From: [REDACTED]
Sent: [REDACTED]
To: Iqraa Malik
Cc: Sian Eggington
Subject: Re: Request for further information A/186/20/HH
Attachments: We sent you safe versions of your files; Roof Solar Array Photo 1.jpg; Roof Solar Array Photo 2.jpg; 1 Arlington Crescent Location Plan rev2.pdf; 1 Arlington Crescent Block Plan rev2.pdf; 1 Arlington Crescent Side Elevation rev3.pdf

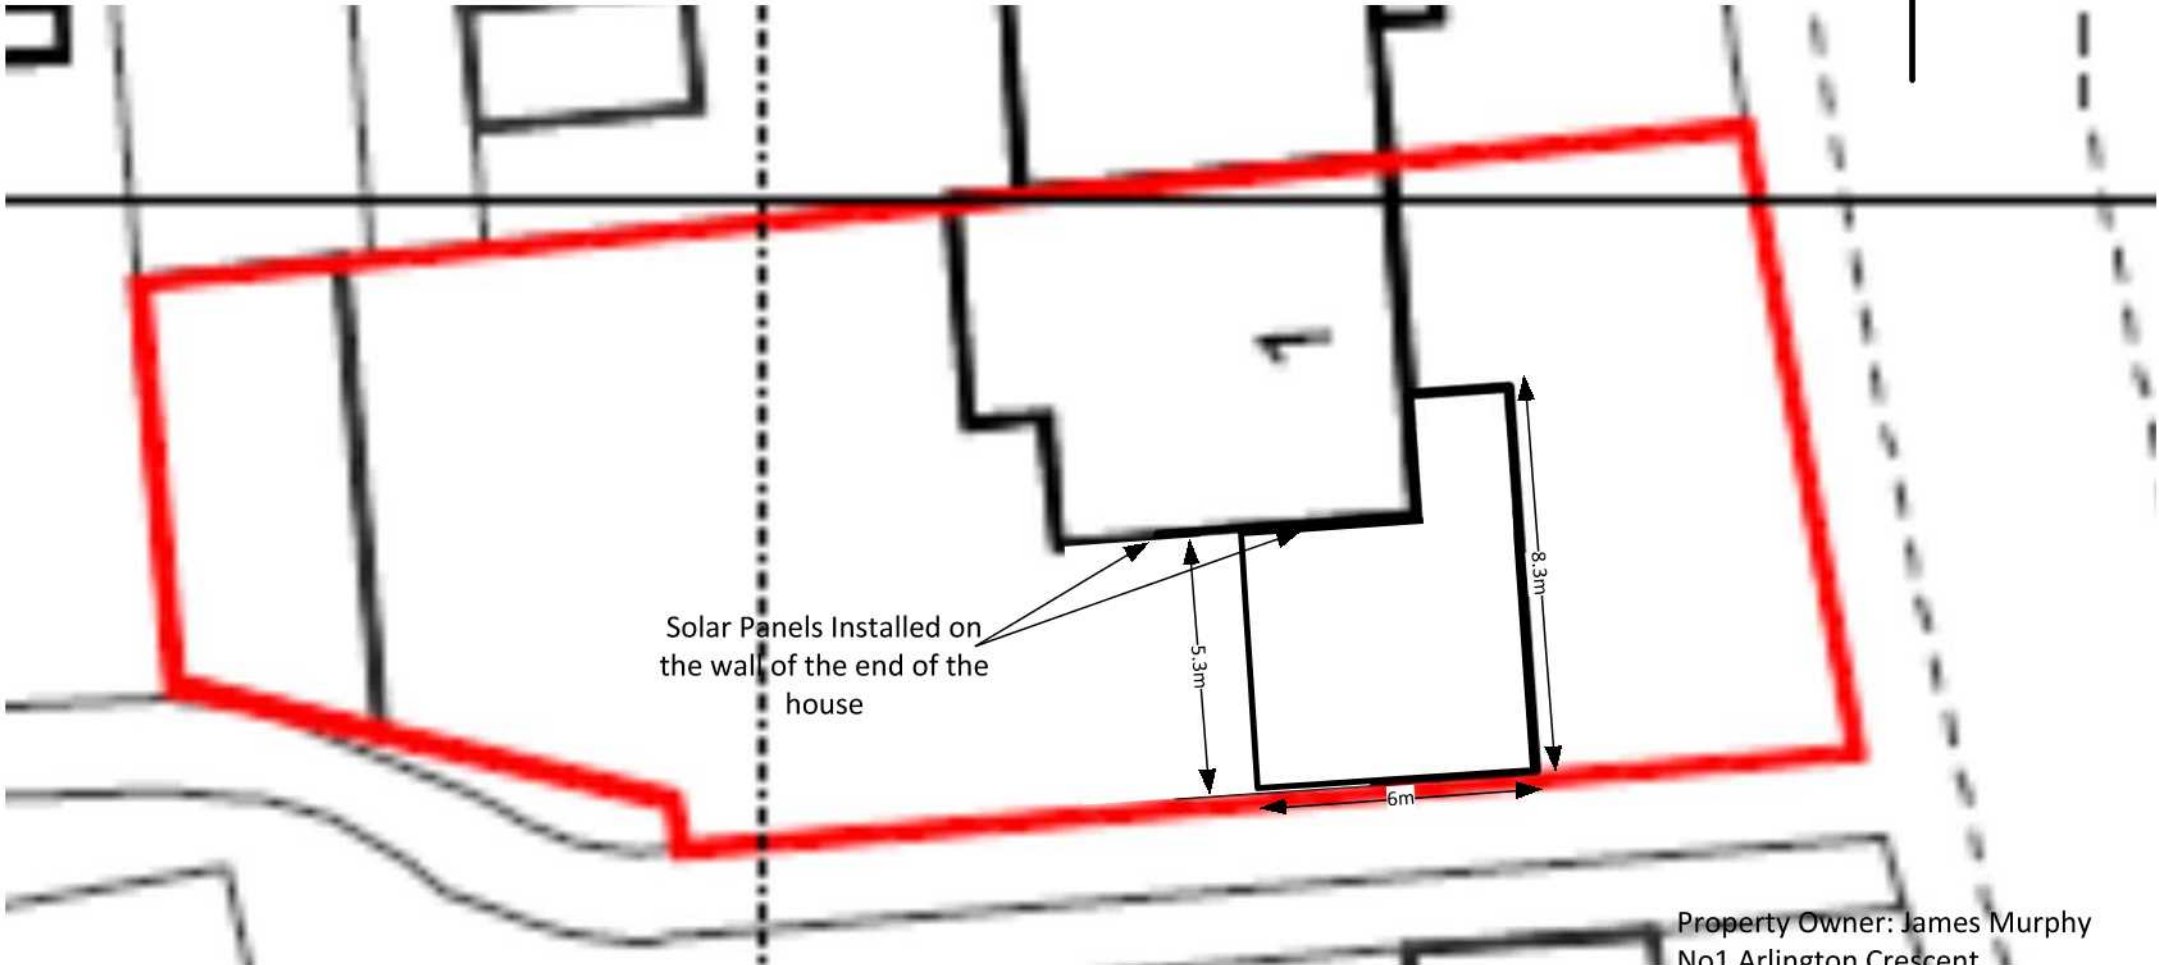
Side Elevation: This also requires a named scale

1:1250 scale print at A5
Centre: 507556 E, 103098 N

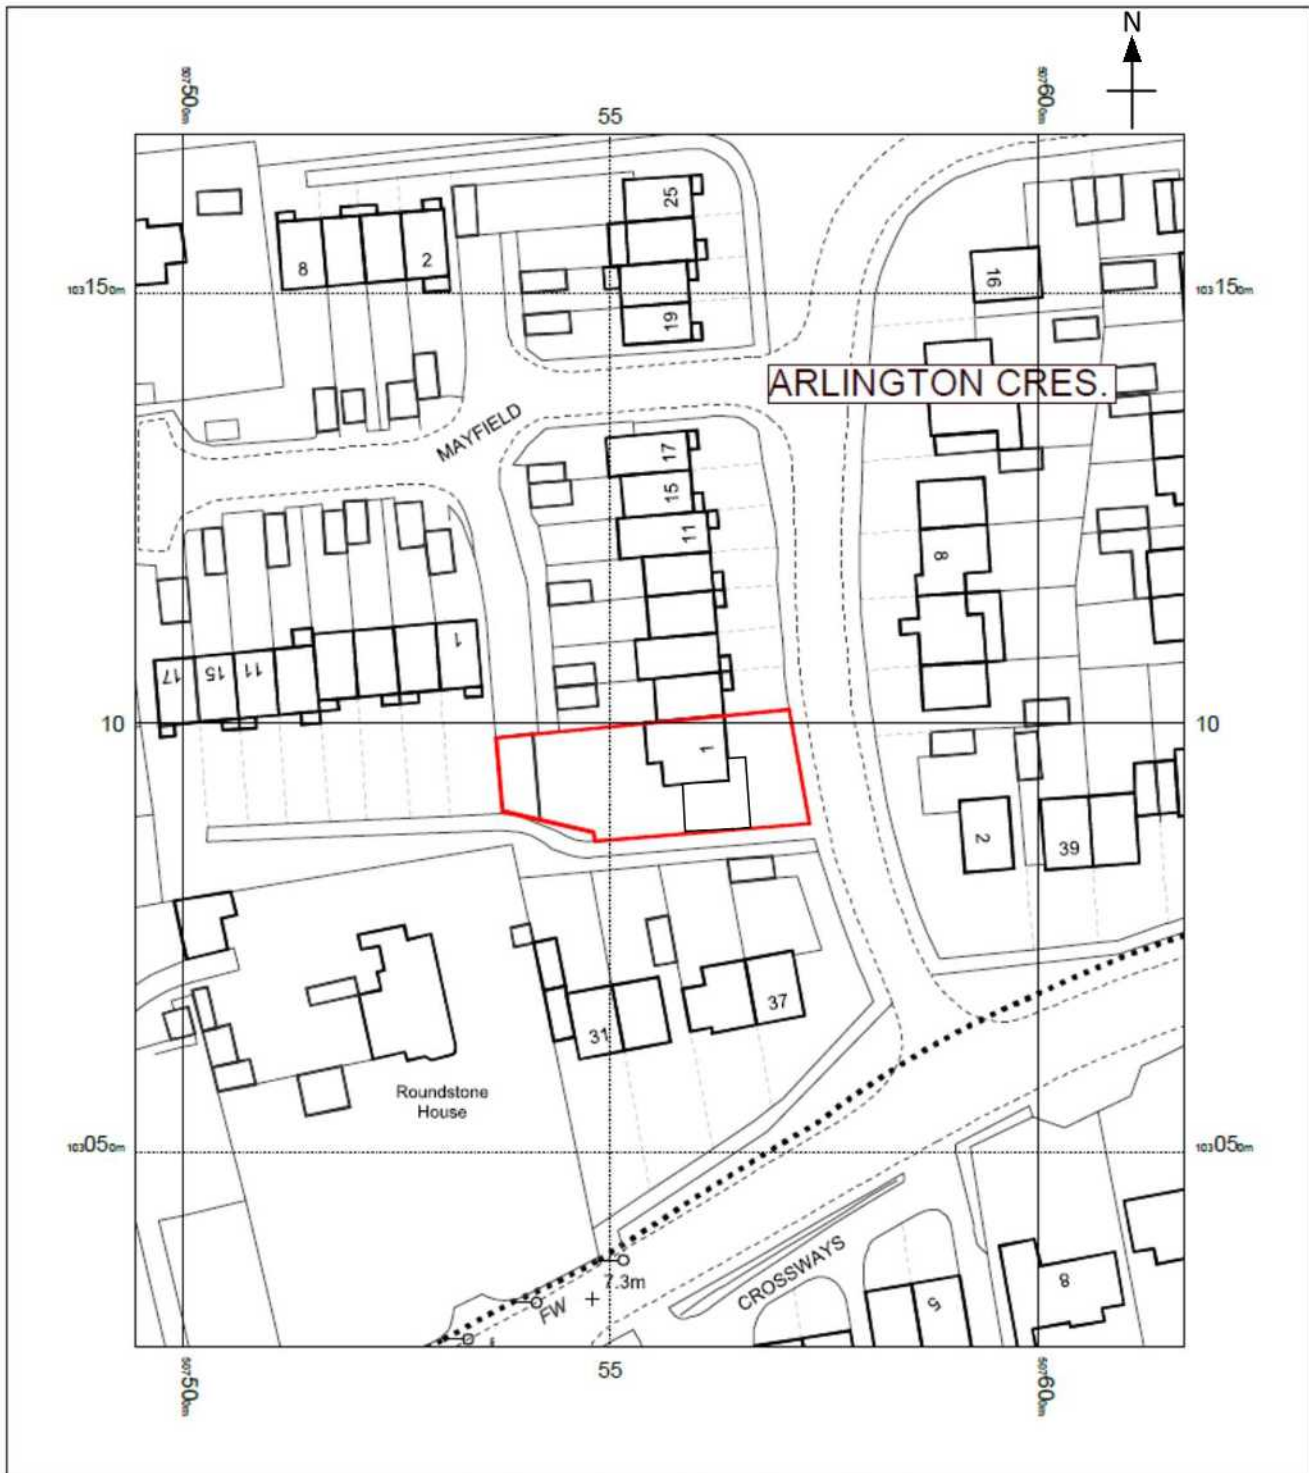
Location plan: Remove the scale bar
